# CITY OF ALBUQUERQUE

**Re: American Toyota, 5995 Alameda**  
**Request for Certificate of Occupancy**  
**Transportation Development Final Inspection**  
Engineer's Stamp dated 12-18-14 (C18-D012)  
Certification dated 04-24-18

**SITE PLAN**

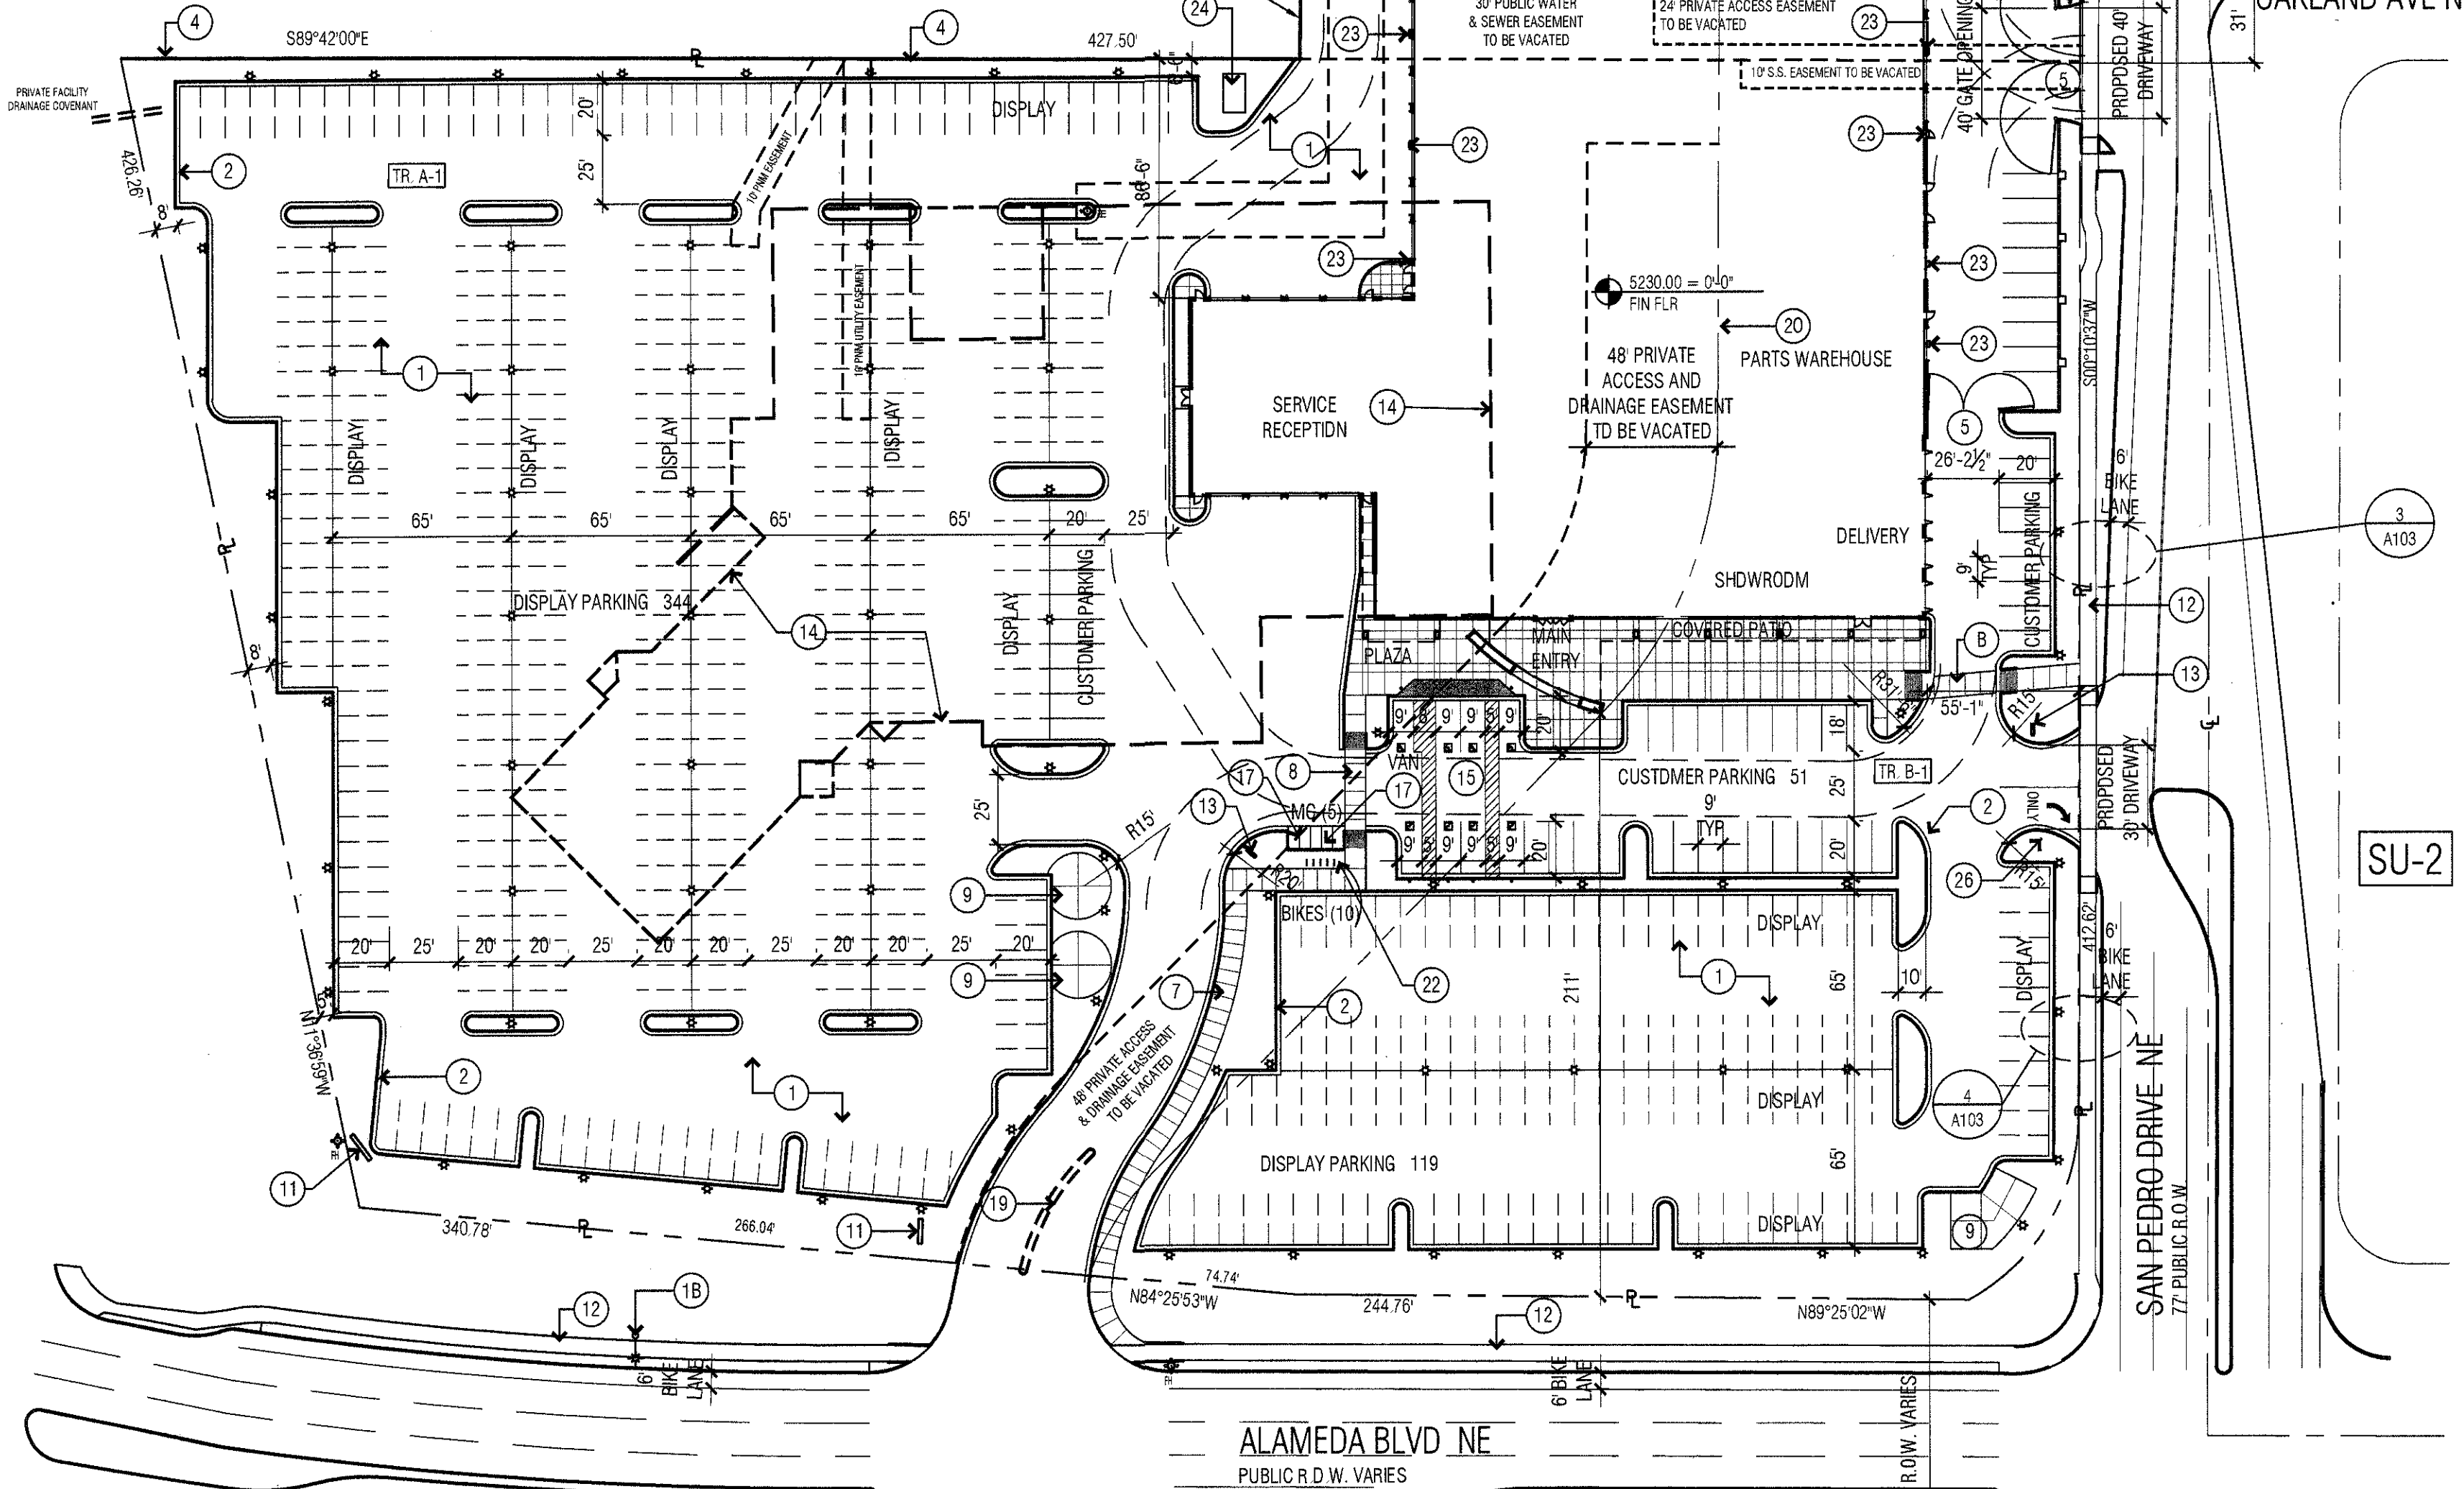
1. The ADA accessible parking sign must have the required language per 66-7-352.4C NMSA 1978 "**Violators Are Subject to a Fine and/or Towing.**" If that language is present it is not visible in the detail.
2. Please add parking bumpers to the two center ADA accessible spaces where the pavement is flush with the ADA ramp.
3. Motorcycle parking spaces shall be designated by its own conspicuously posted upright sign, either free-standing or wall mounted per the zoning code.
4. Please close the unused curb cut on San Pedro Dr. at the north end of the site with curb & gutter (Standard Drawing 2415) and sidewalk (Standard Drawing 2430).
